YorkshireWater

Your Ref: 2023/91491

6th July 2023

Prickleden Mills, Woodhead Road, Holmfirth – Erection of 61 age-restricted apartments with ancillary accommodation including separate residents lounge and manager facilities and associated external works, including the erection of access bridge and riverside walk featuring two pedestrian bridges

2659 (100)10 /

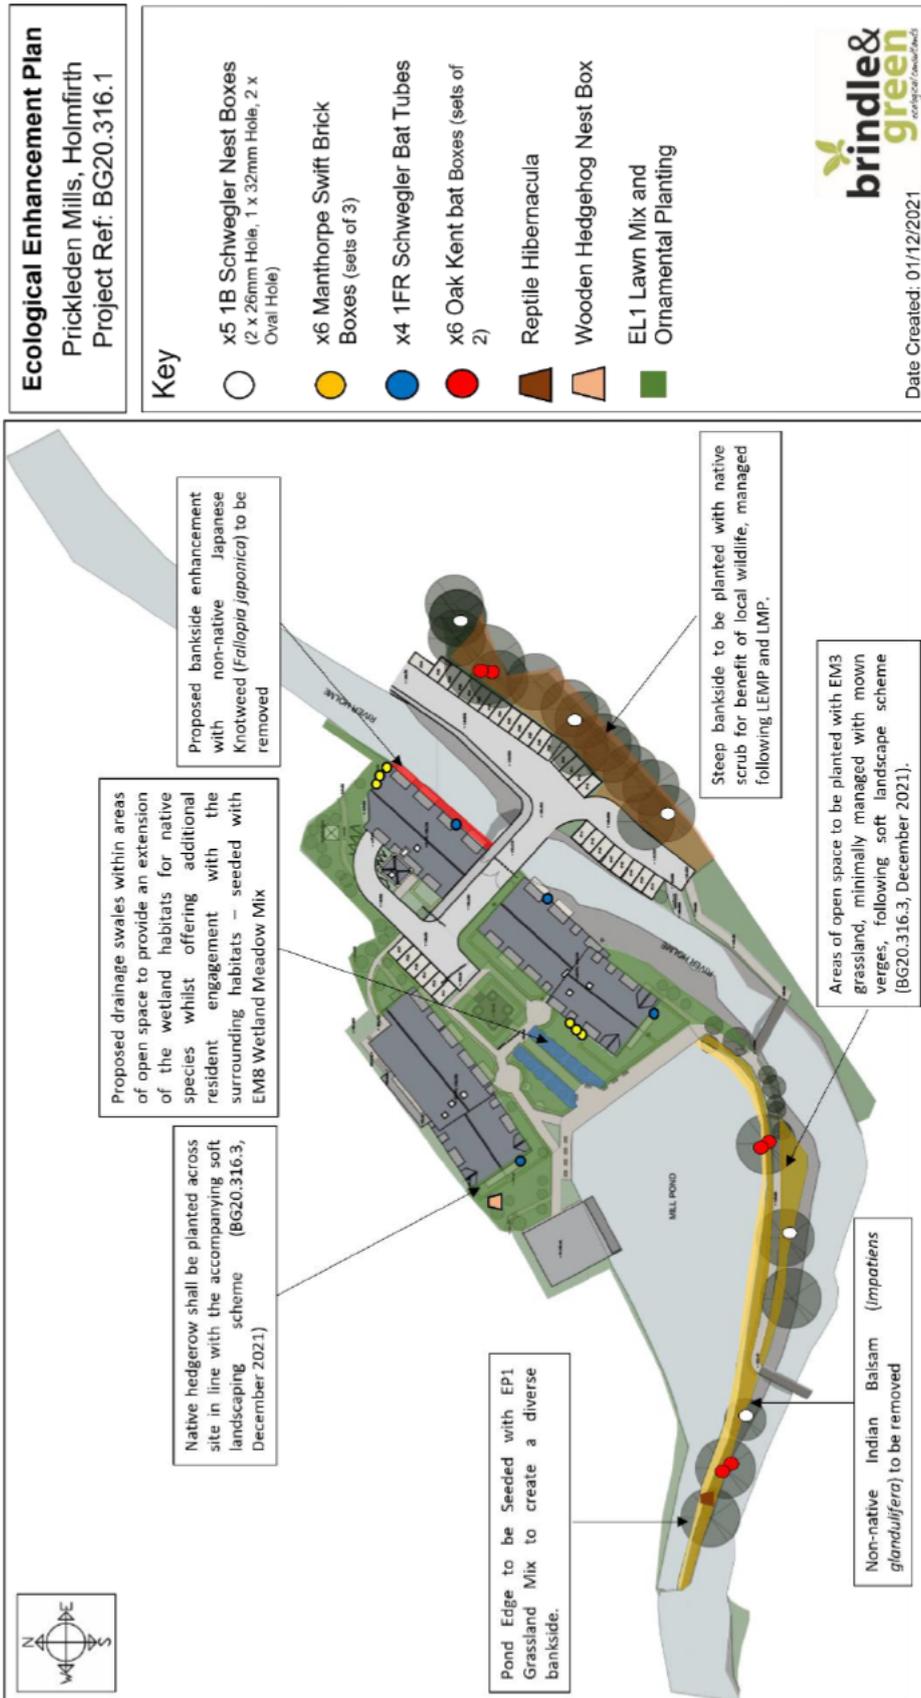
b.) The submitted proposed block plan (100)10 (rev D) dated 19/06/23 as prepared by Acumen, indicates that the northernmost building will be situated directly over, if not very close to the 300 mm diameter sewer, which is not acceptable.

2) We strongly recommend that the developer conducts a site survey to determine the accurate location of all on-site drainage, so the layout can be altered to suit the sewer's associated stand-off distance.
